15 March 2024

**SECTION 73 APPLICATION TO VARY CONDITION 1 RELATED TO APPROVED DRAWINGS TO PLANNING CONSENT 23/00863/FUL.
AT BOB'S FARM, VYNE ROAD, SHERBORNE ST JOHN, HAMPSHIRE, RG24 9HX.
FOR THE ERECTION OF 9 DWELLINGS AND ASSOCIATED LANDSCAPING, ACCESS AND CAR PARKING FOLLOWING THE DEMOLITION OF EXISTING AGRICULTURAL AND B8, STORAGE AND DISTRIBUTION USE BUILDINGS AND HARDSTANDING.**

JOB NO.: 8160 DRAWING NO.: D20 REV: B

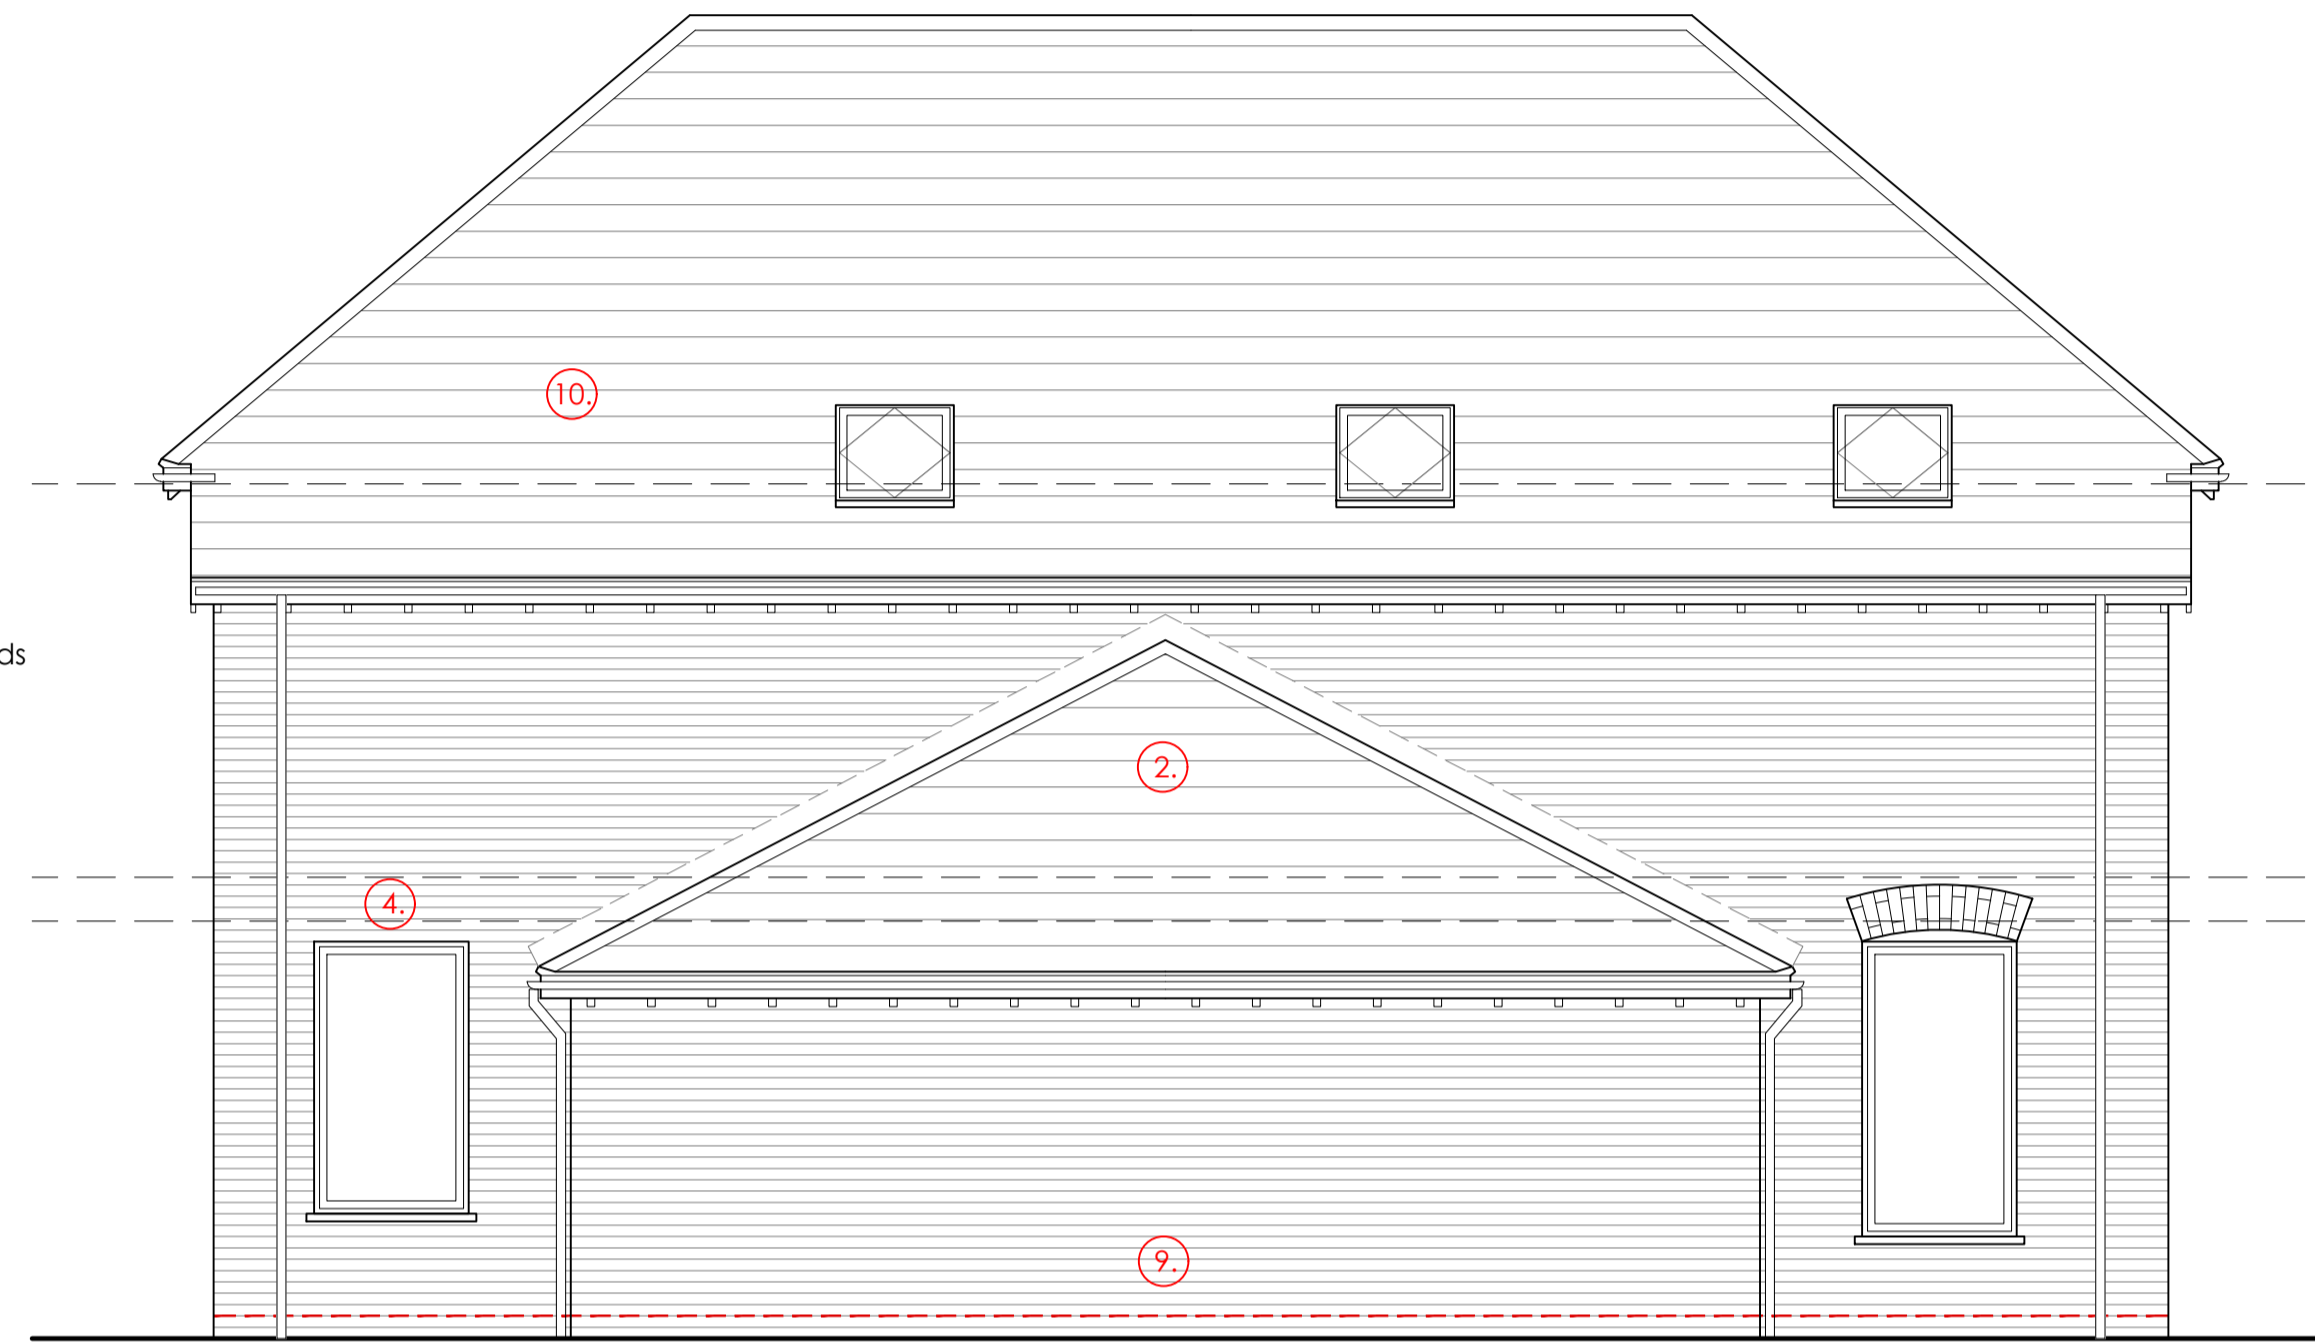
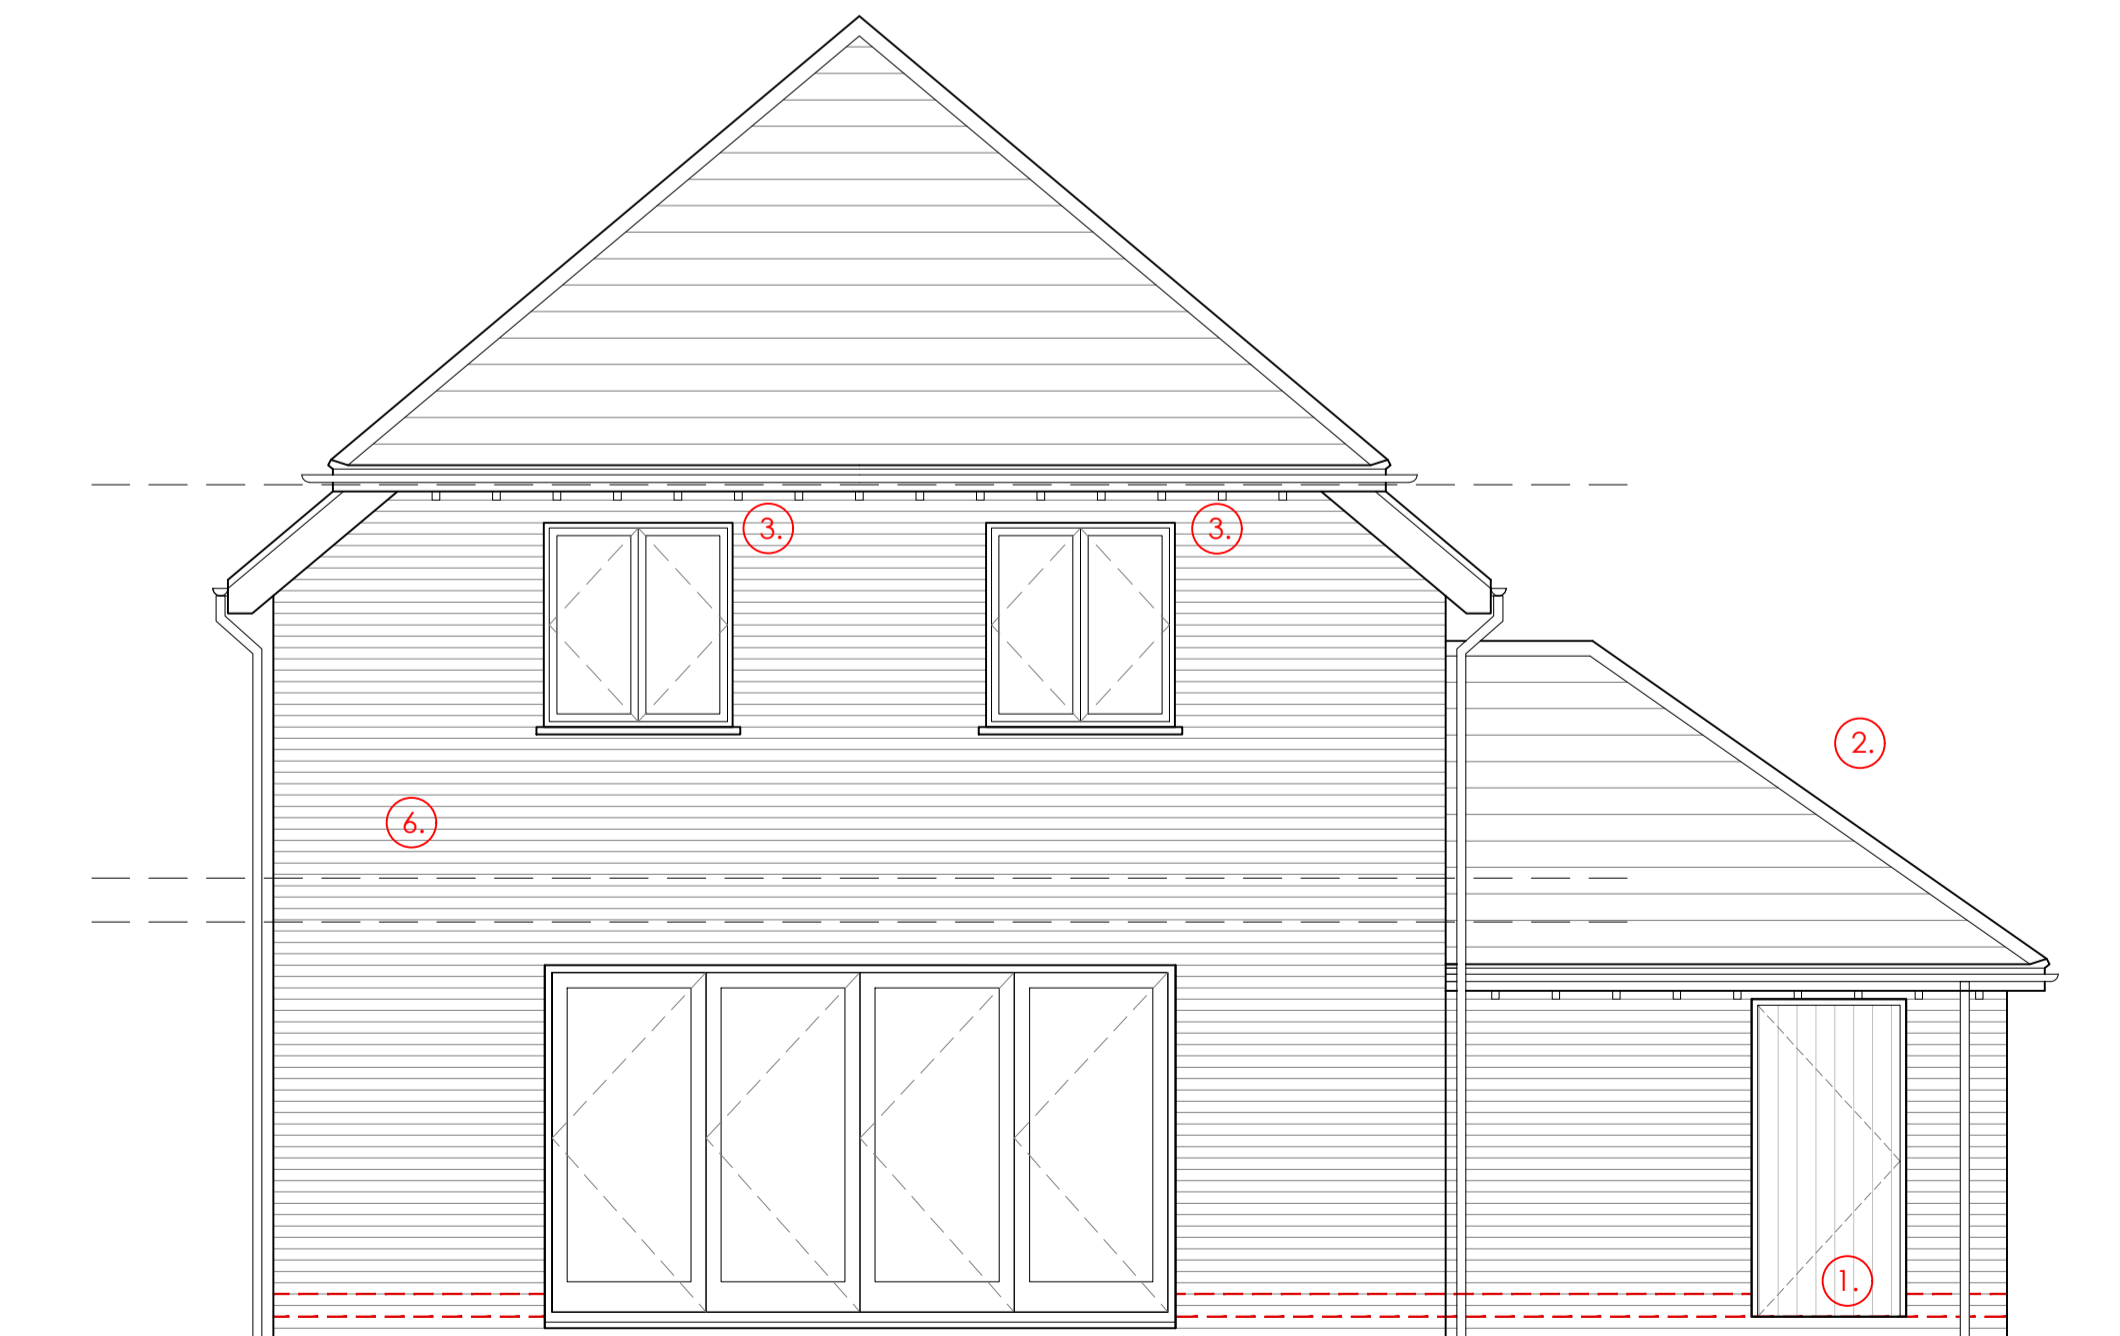
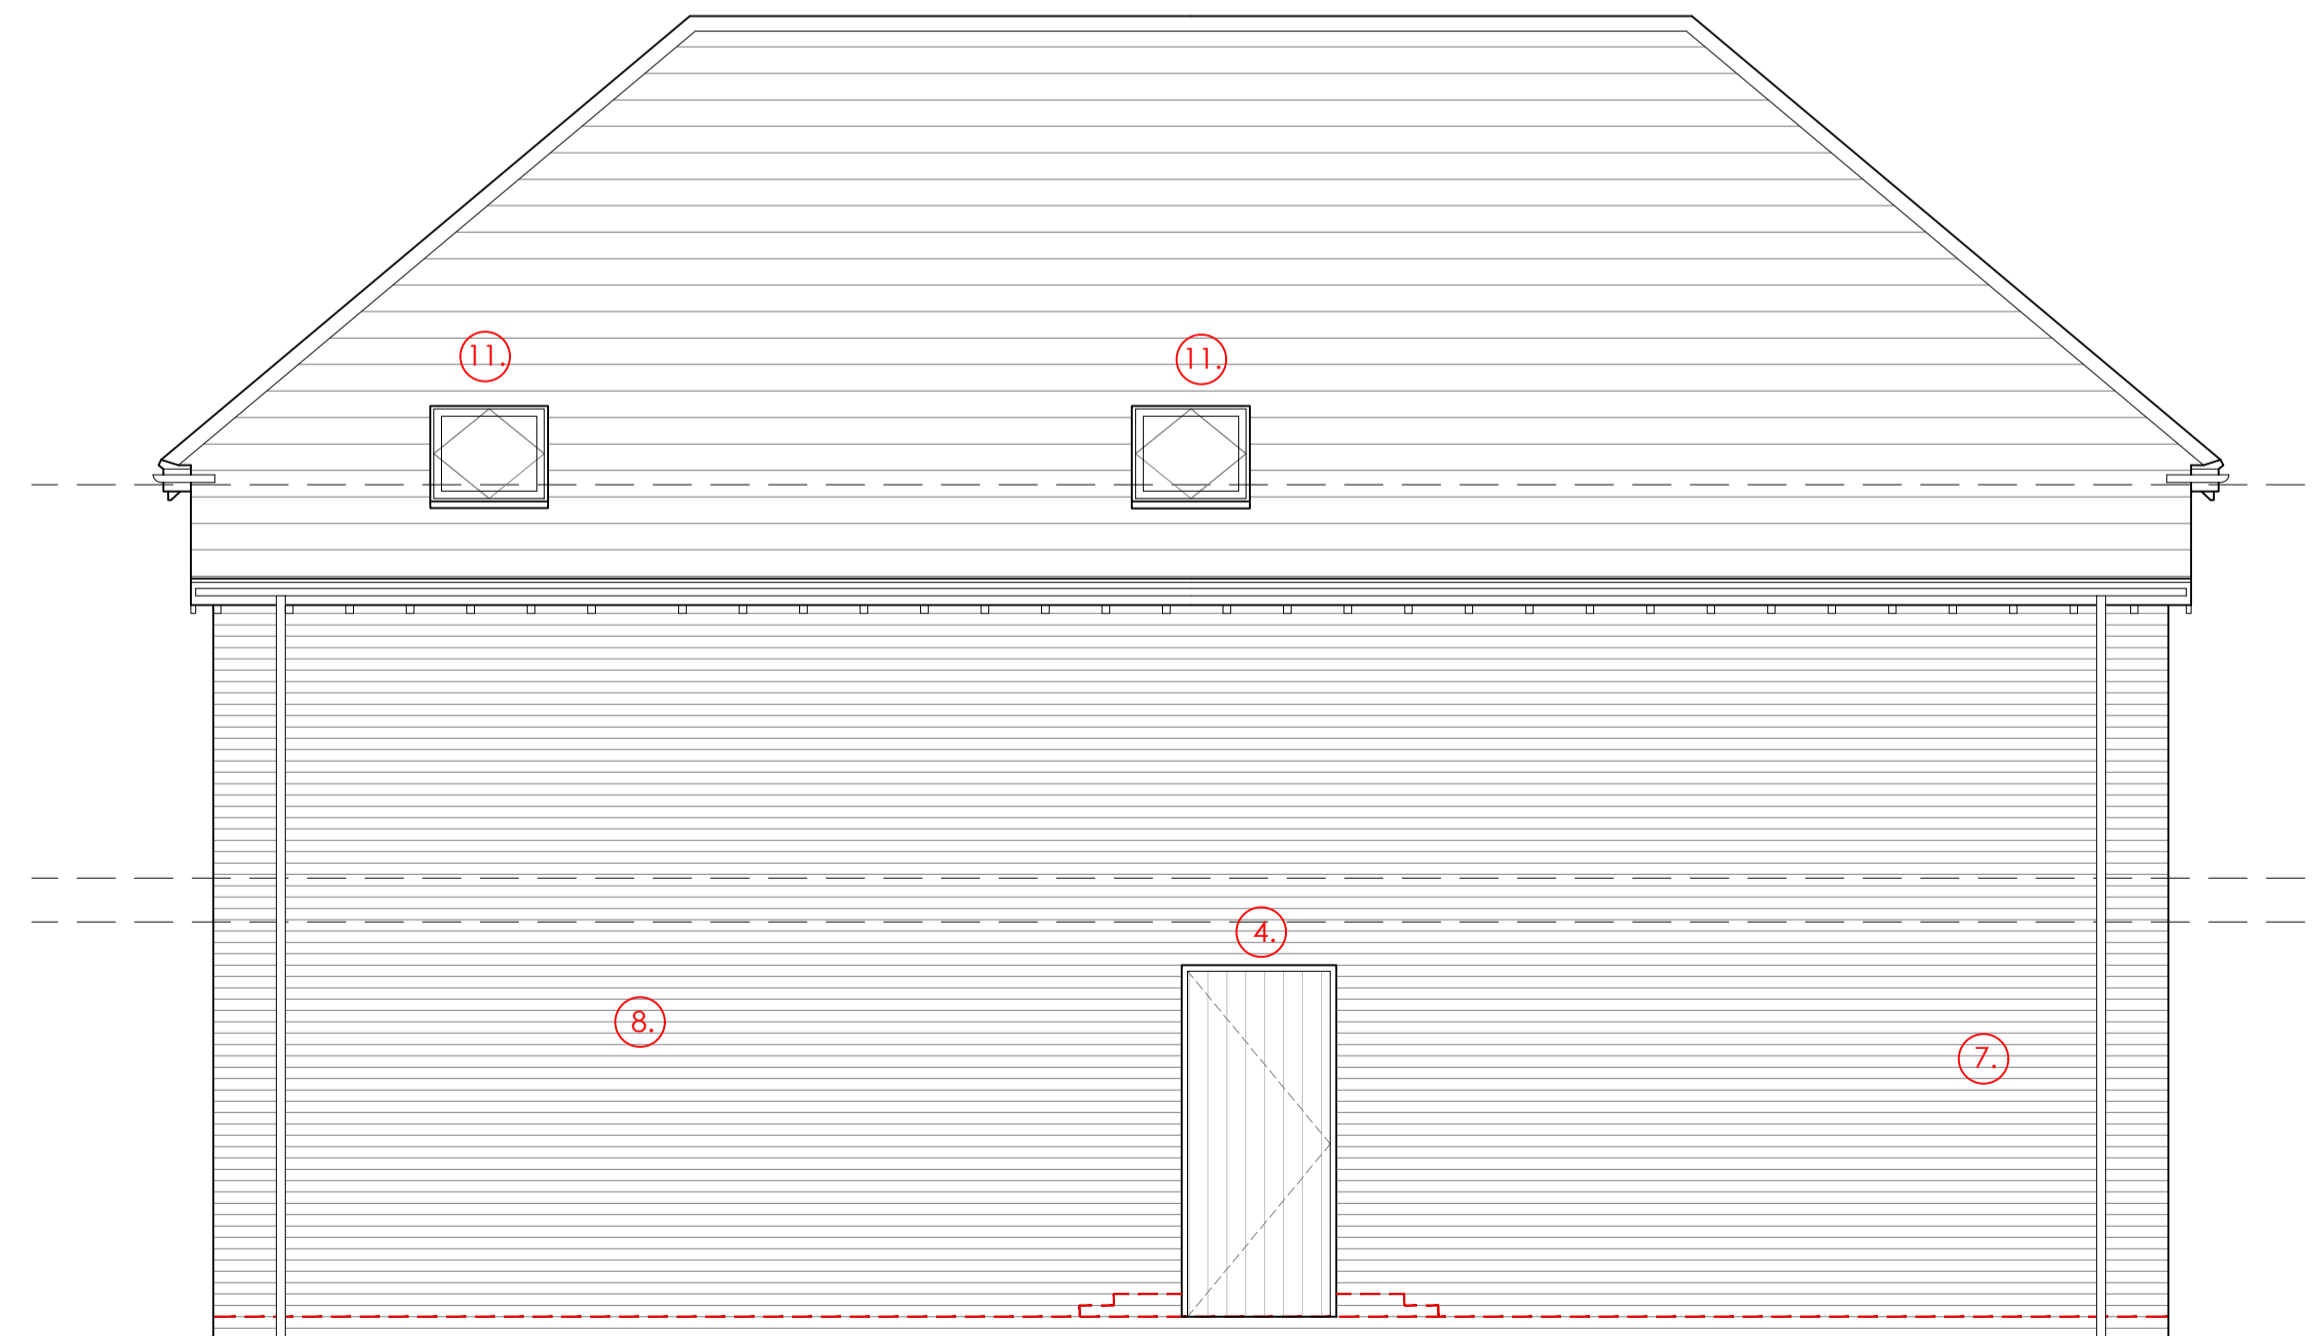
- Plot 6 – amend roof type to omit flat roof.
- Plot 7 – fenestration changes including adding door and windows, and remove windows; remove chimney; garage position set back slightly, design altered and scale reduced.
